Our Reference: PA-0004779/03
Customer reference: 3/2026/0238
Date: 19 August 2026

Approval of details reserved by conditions 3 (construction management plan/method statement) 4 (surface water) 5 (bat boxes) 7 (street maintenance) 8 (flood mitigation) 9 (flood management plan) 10 (surface water/foul drainage) 19 (cycle storage) 20 (travel plan) and 21 (operation/maintenance manual) on planning permission 3/2022/1158 granted on appeal APP/T2350/W/25/3368139.

Land South of Accrington Road, Whalley

COMPENSATORY STORAGE SECTIONS

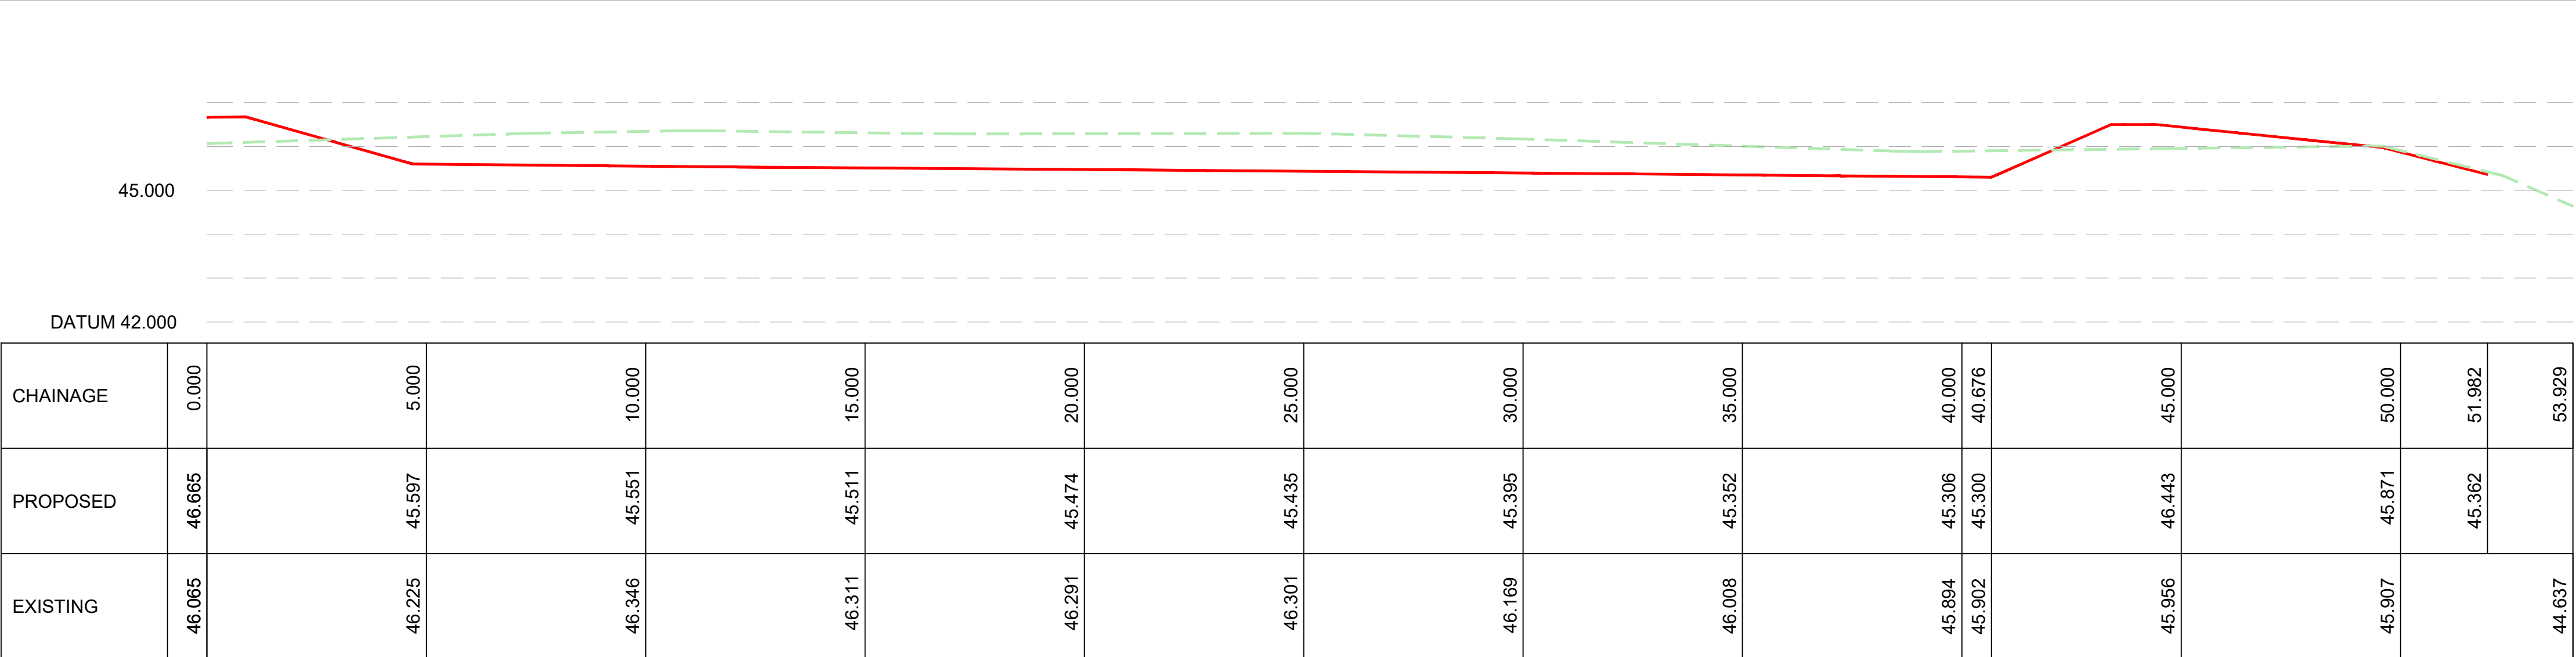
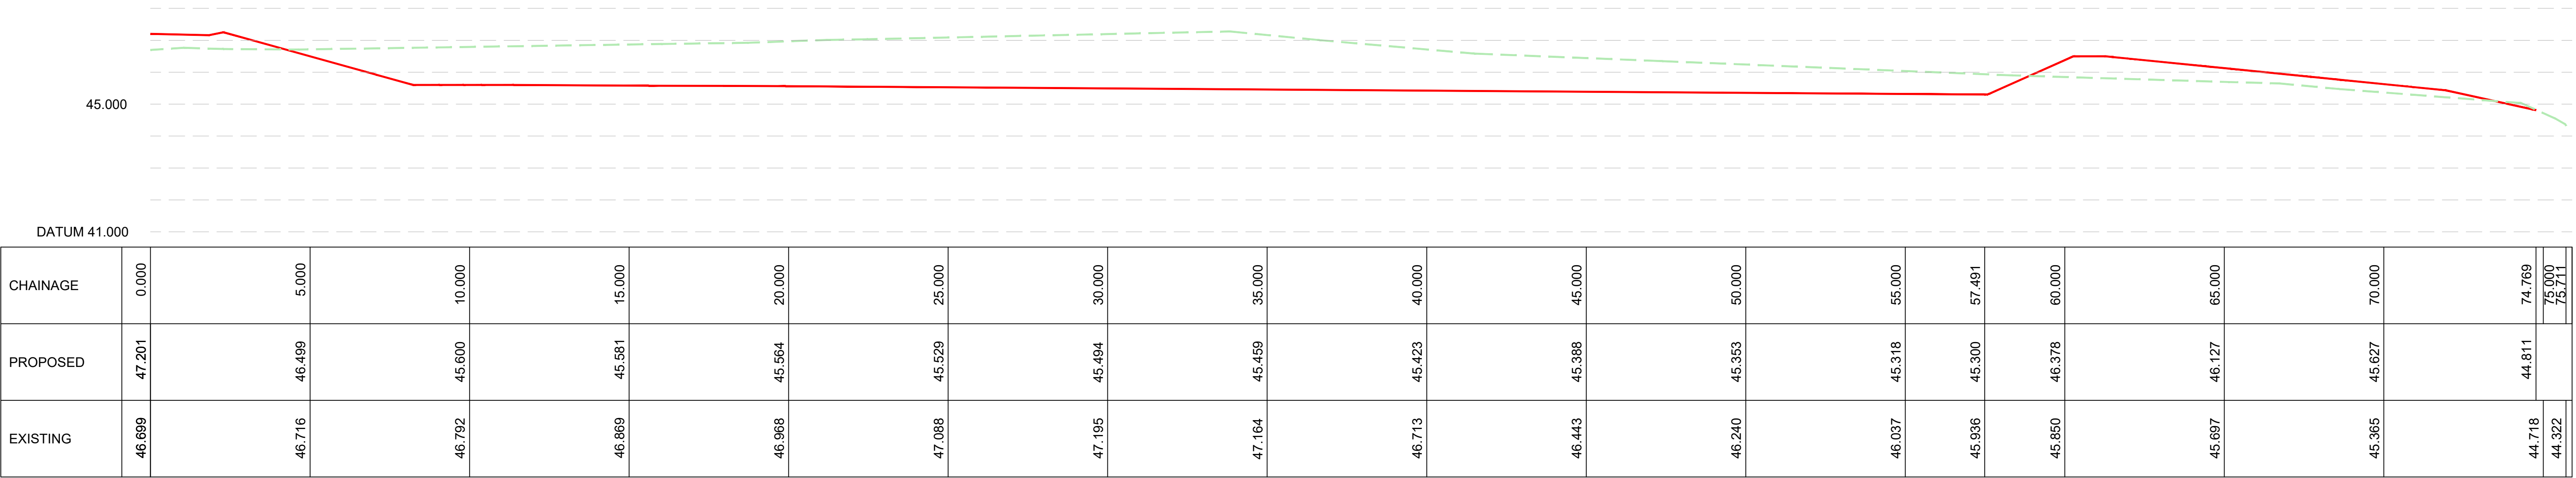
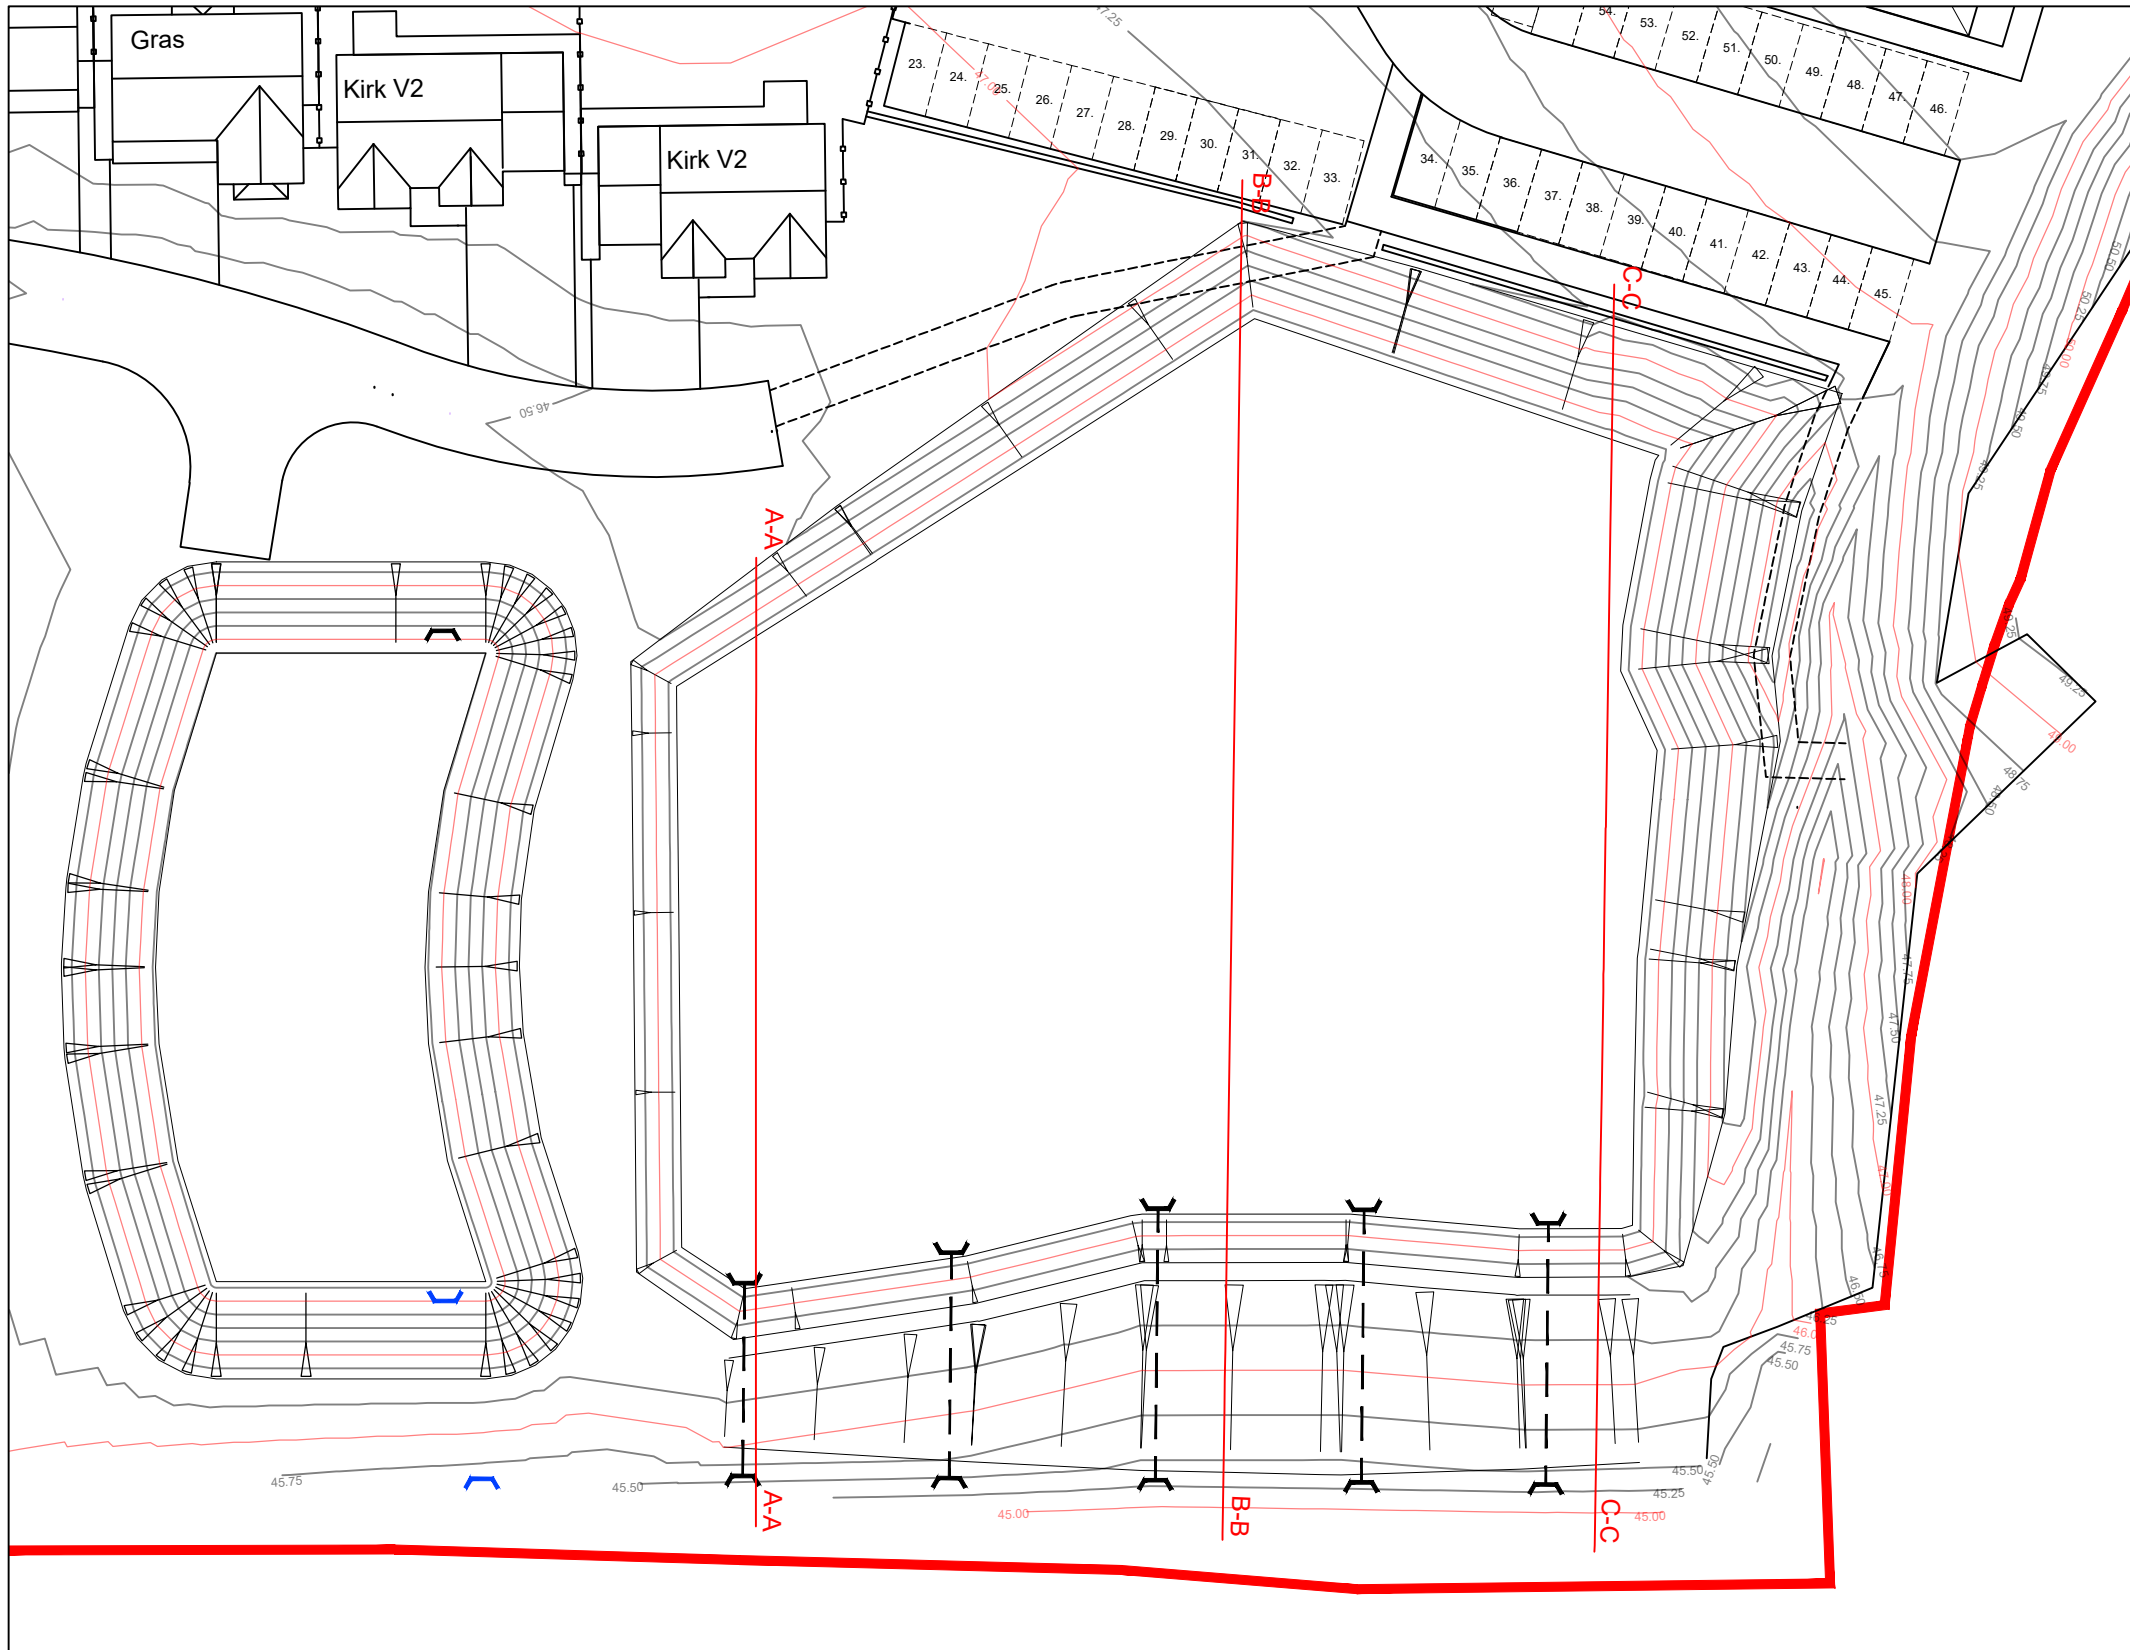
Whilst additional information has been provided, we do not consider that sufficient detail has been submitted to demonstrate the final engineering solution required by

Condition 8. In particular, further clarification is required regarding the detailed design solution and the provision of proposed construction cross-sections in proximity to the River Calder, which is designated as a Main River and forms the southern boundary of the site.

There remains insufficient information to demonstrate that suitably engineered, stable, and maintainable ground conditions will be provided, particularly in areas where works are proposed over or adjacent to the five Flood Compensation Area (FCA) culverts. Furthermore, in the absence of this information, it is not possible to determine whether adequate consideration has been given to future access arrangements and maintenance requirements.

The engineering concerns outlined above relate to the area of land between the River Calder and the site. This area includes the retaining embankment for the compensatory flood storage area and is perforated by 5 no. 450mm diameter fill/drain down outfalls.

Insufficient information has been submitted to demonstrate the provision and retention of a suitably engineered 8-metre-wide access corridor. This would facilitate access by appropriately sized medium and heavy plant to the weir, should such access be required for the removal of debris blockages, reactive repairs, or future improvement works.

support the proposed works, particularly in relation to the interface with the River Calder and the FCA culverts.

Please refer to our previous letter and the points highlighted above and address the matters systematically, paying particular attention to the proposed construction details forming the area of land between the River Calder and the site.

This should include sufficient information to demonstrate how the full 8-metre access corridor adjacent to the Main River will be retained and maintained for the lifetime of the development and how this can be achieved without compromising the integrity, operation, maintenance and long-term functionality of the compensatory flood storage scheme and associated infrastructure.
